Project Name: **Riverside Golf Course Pro Shop**
Project ID: #2012-432
Address: 1158 Riverside Street CBL: 357-A-1
Applicant: Portland Department of Public Services
Planner: Jean Fraser

On November 26, 2012, the Planning Authority approved with conditions a Level II site plan for the construction of a new Golf Course Pro Shop and reconfigured parking lot and pedestrian access at the Riverside Golf Course at 1158 Riverside Street.

SHEET #  
C003  
PLAN NUMBER

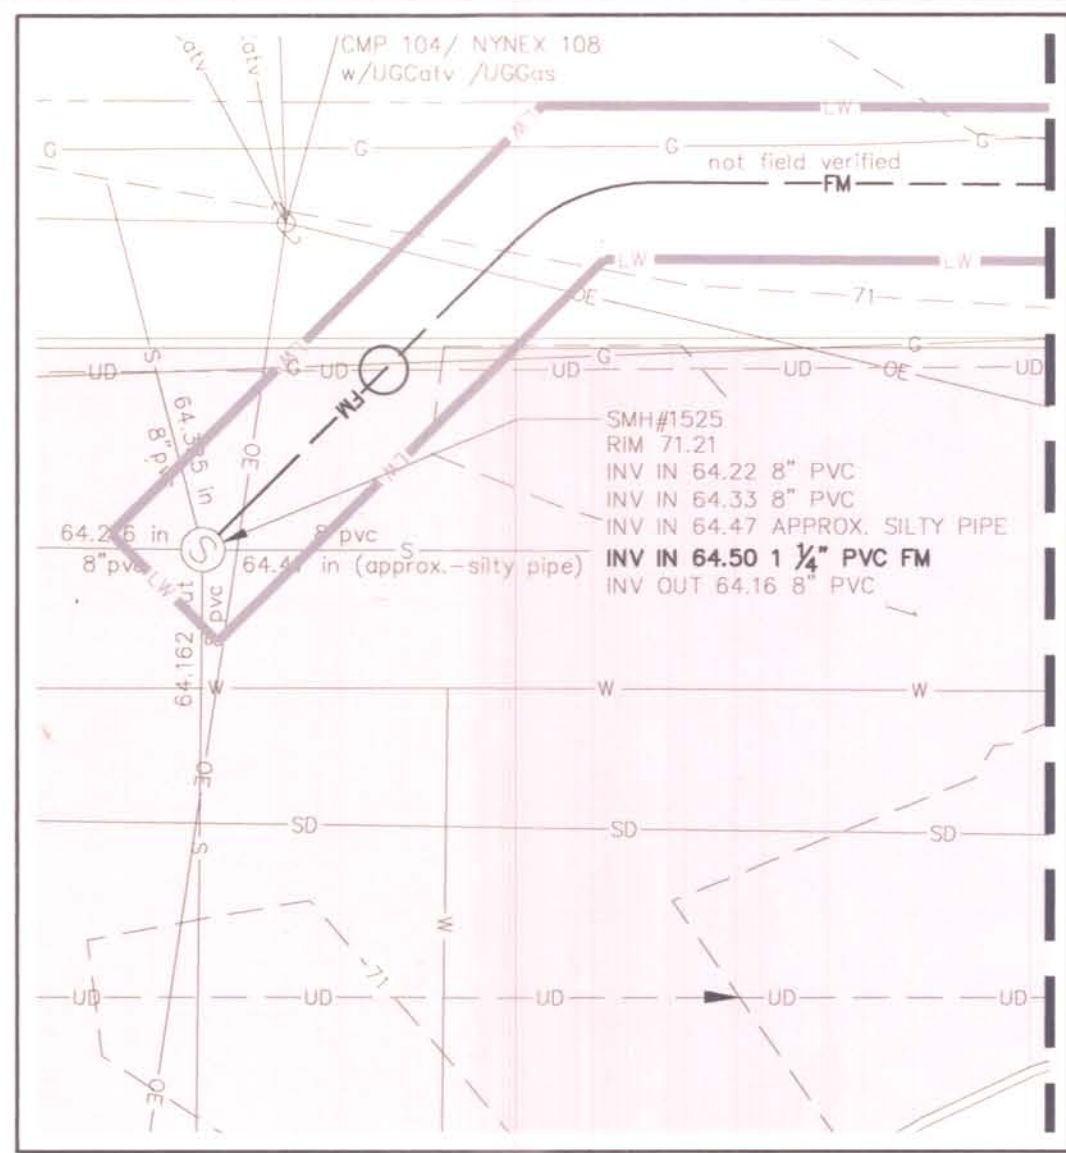
1. That the applicant shall submit a detailed Landscape Plan for review and approval by the City Arborist and Planning Authority prior to the issuance of a building permit. The Landscape Plan shall incorporate additional planting to meet the Site Plan standards for parking lot landscaping and shall show all existing trees to be protected during construction and retained, and all new planting (showing location, size and species); and

2. That the applicant shall include in the Landscape Plan (see Condition #1) the design for an enclosure of the condenser on the Riverside Street side of the proposed building, and also show the location and screening of any exterior waste receptacles; and

3. That the applicant shall include in the Landscape Plan (see Condition #1) a full cut off type light fixture on the utility pole on the property line (or on any relocated sign or similar support in the vicinity) near the 5 foot wide walkway where it meets the sidewalk/parking near Riverside Street, to illuminate the pedestrian access walkway and nearby parking spaces; and

**RIVERSIDE SOUTH GOLF COURSE
 PROPOSED SIDEWALK CONSTRUCTION
 & PAVEMENT MARKING PLAN**

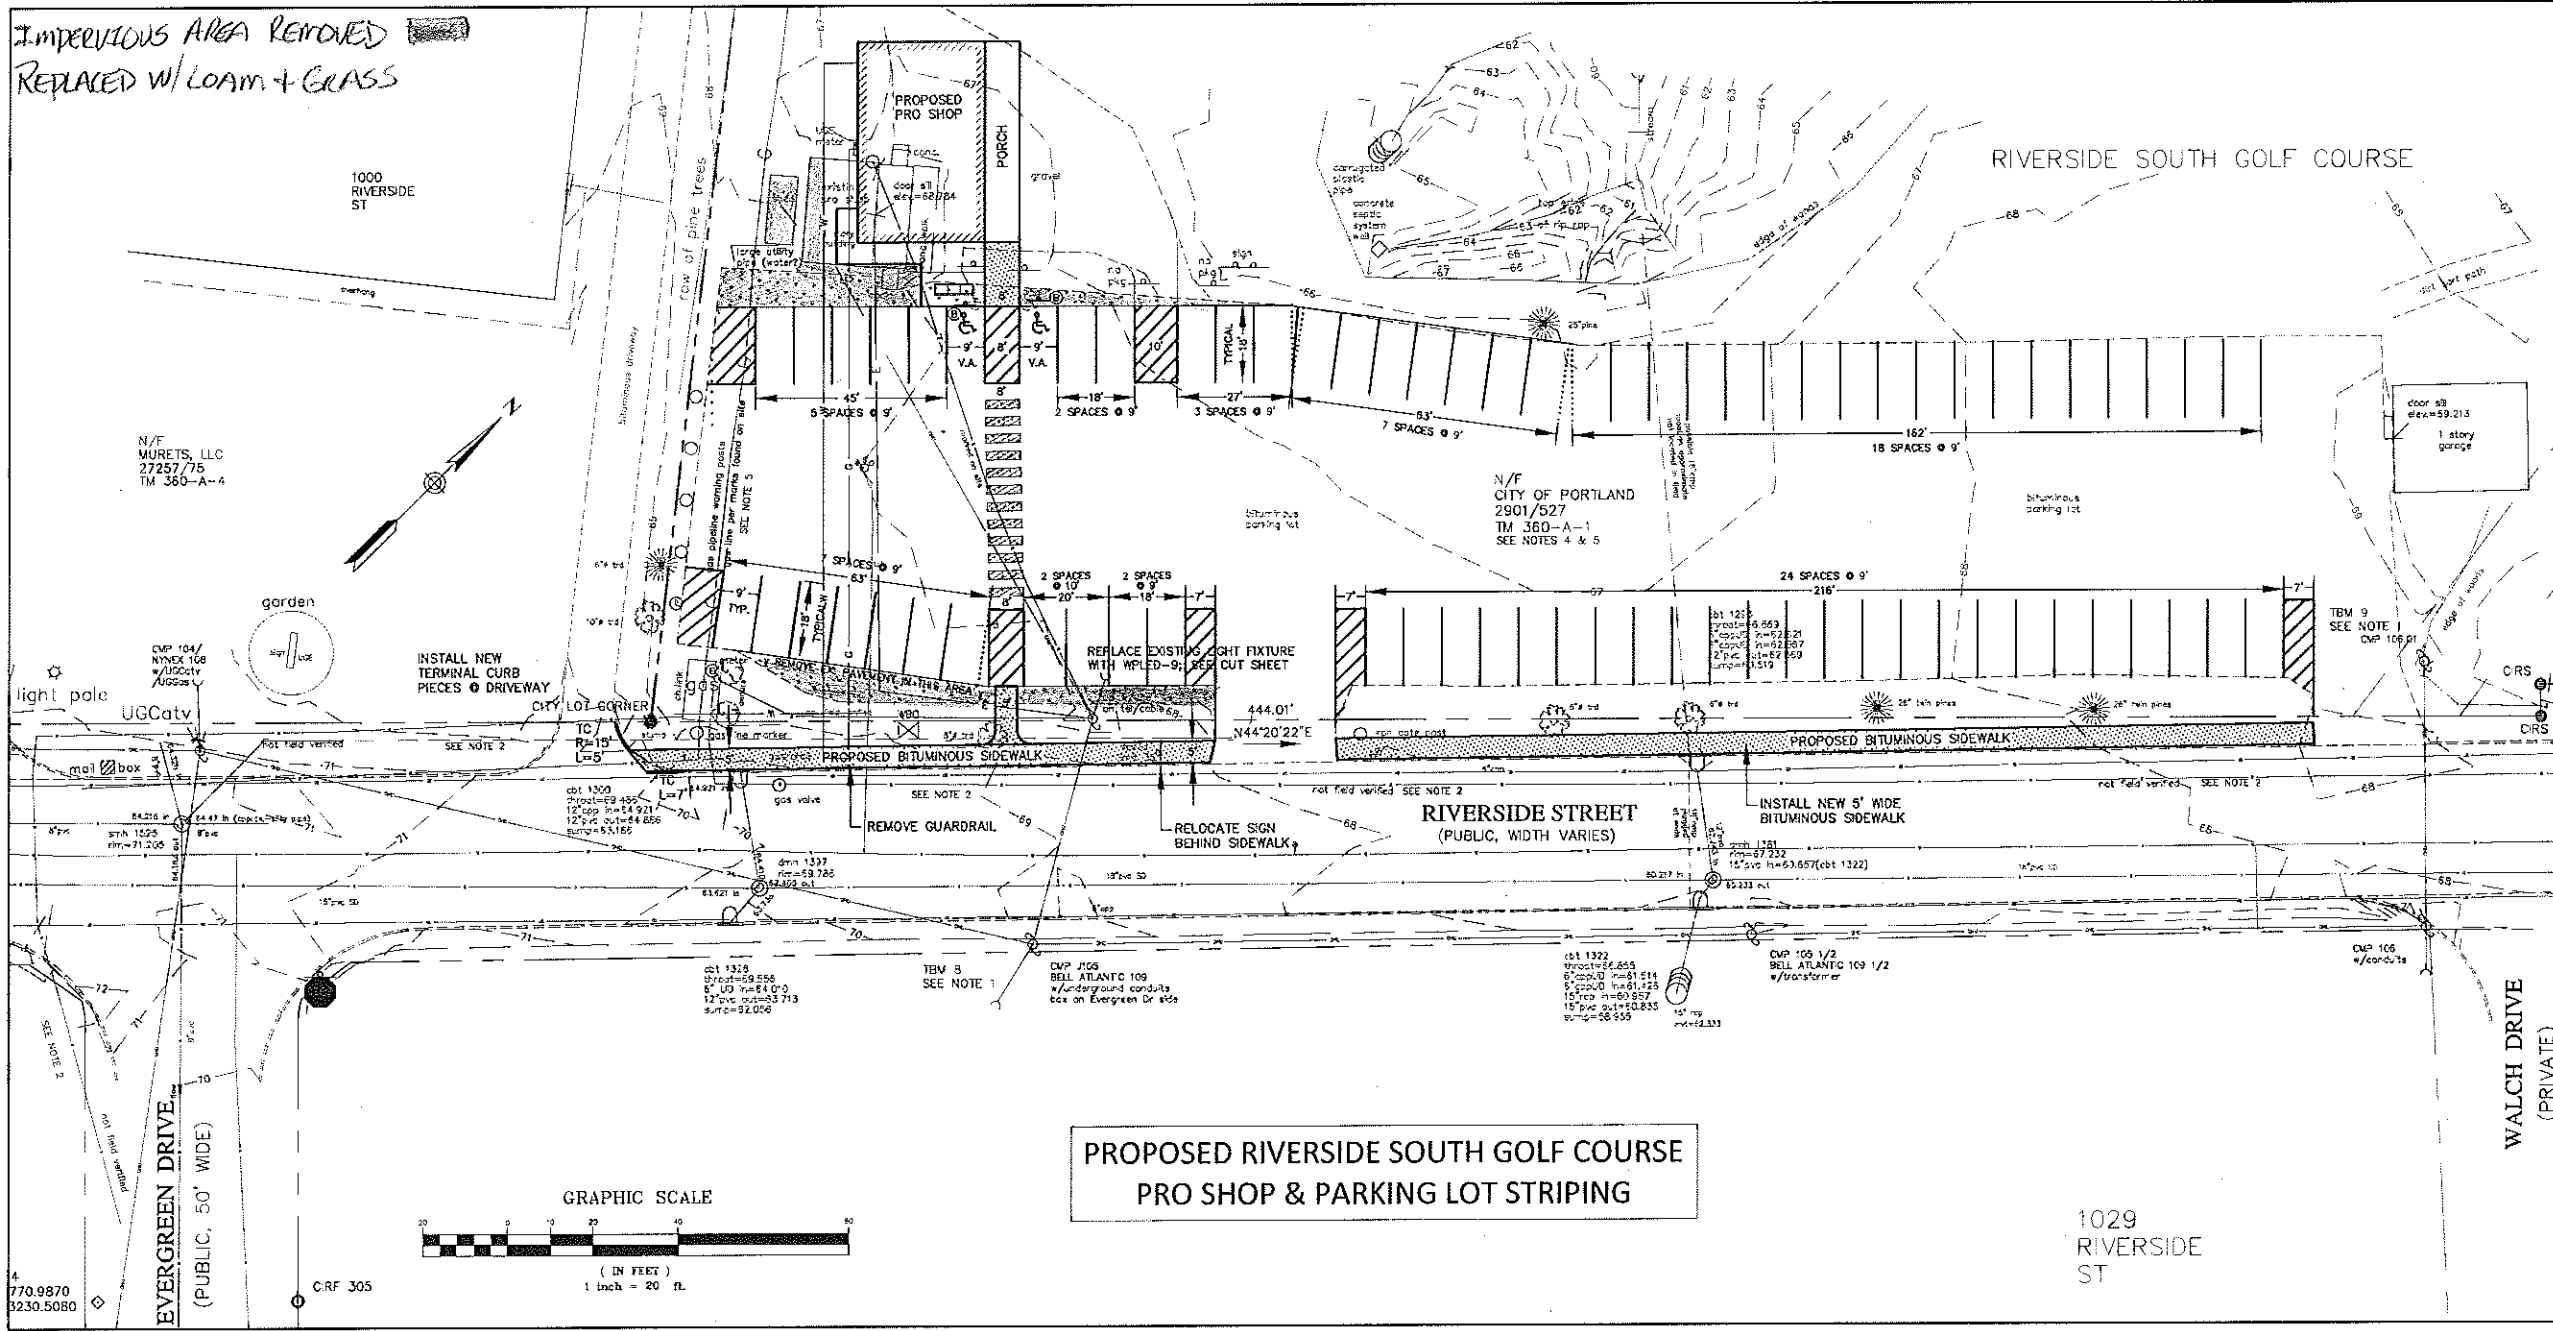
7. That any new or relocated sign requires a separate permit through the Inspections Division; and
8. That the applicant shall construct the sidewalk, as shown on the "Plan of Sidewalks and Parking Layout" dated 9.10.2012, on or before June 15, 2013.
